KITTITAS COUNTY COMMUNITY DEVELOPMENT SERVICES

Subject: CDS Review of LPF-22-00008 Stanavich Final Plat – Request for additional information

Subject: LPF-22-00008 Stanavich Final Plat – Staff Review, Request for Additional Information.

SHEET 1 OF 2

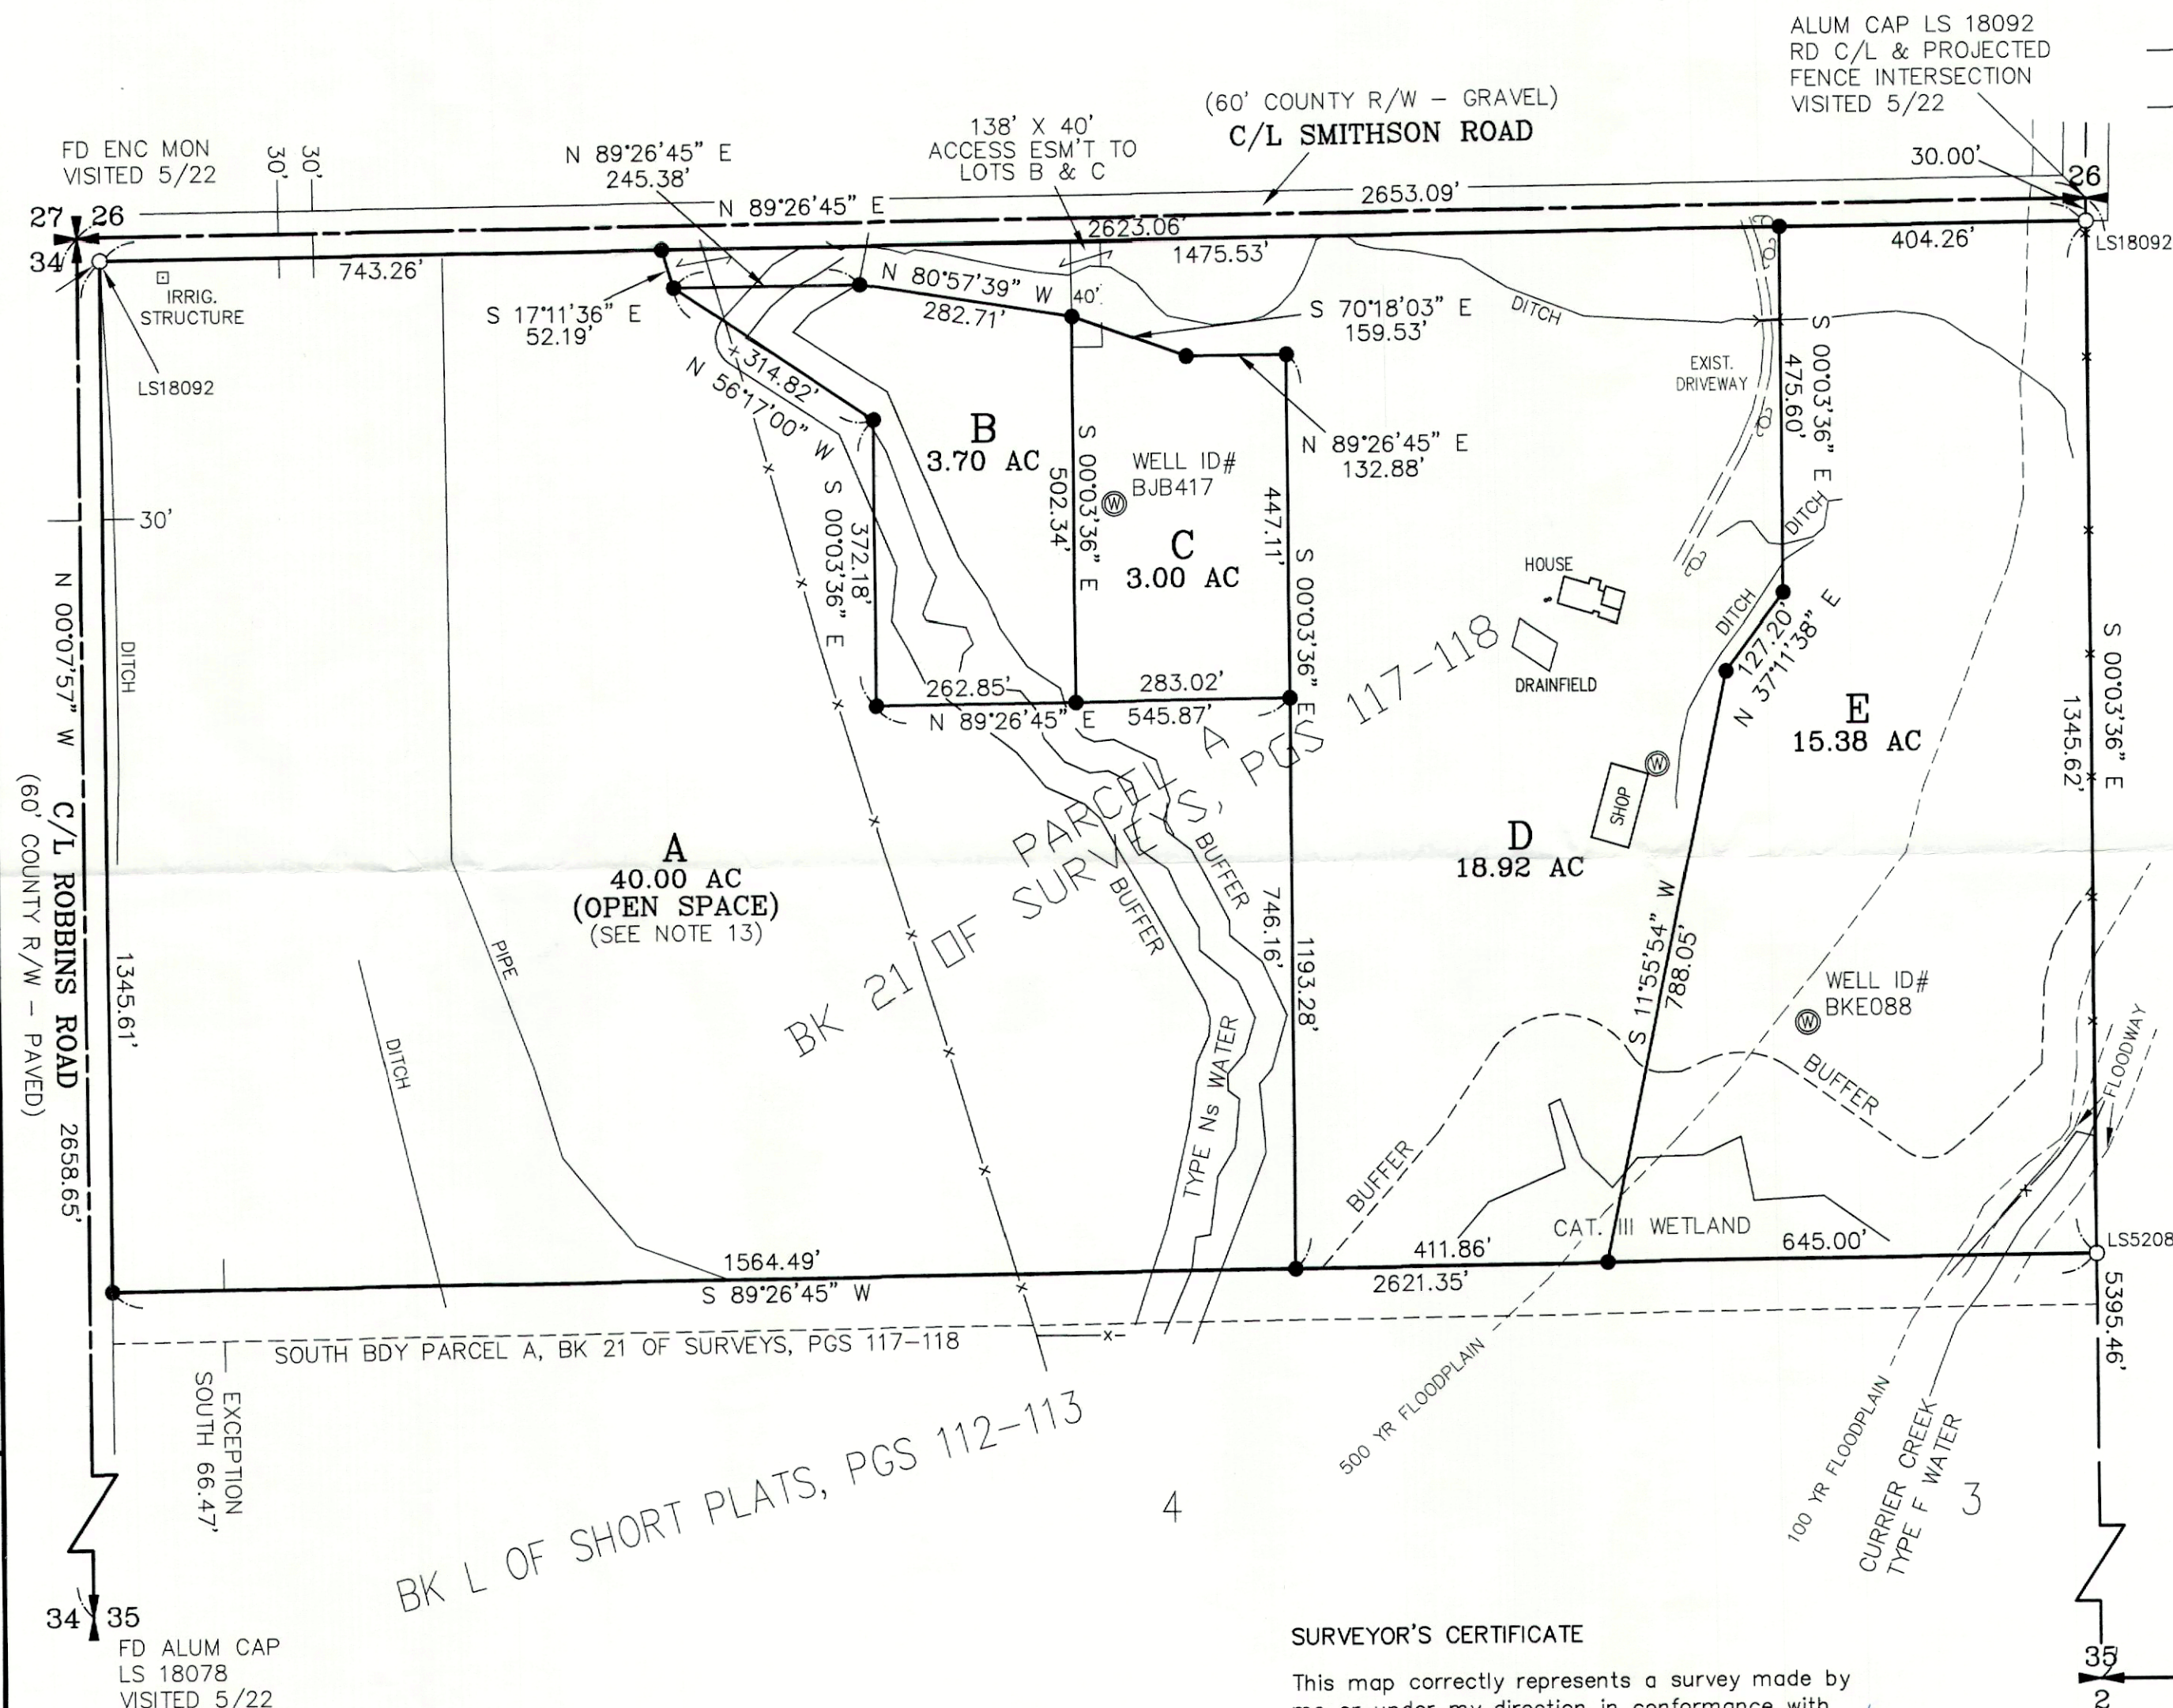
- The final mylars shall note the final plat file number LPF-22-00008 on the face of the plat.
- KCC 16.09.040(1)(a) requires final plat to contain the following notice: *“The subject property is within or near existing agricultural or other natural resource areas on which a variety of activities may occur that are not compatible with residential development for certain periods of varying duration. Agricultural or other natural resource activities performed in accordance with county, state and federal laws are not subject to legal action as public nuisances. Kittitas County has adopted right to farm provisions contained in the Section 17.74 of the Kittitas County Zoning Code.”* Plat note 8 of the Final Plat has a majority of this notice, however portions are missing. Please update to ensure compliance with KCC 16.09.040(1)(a).
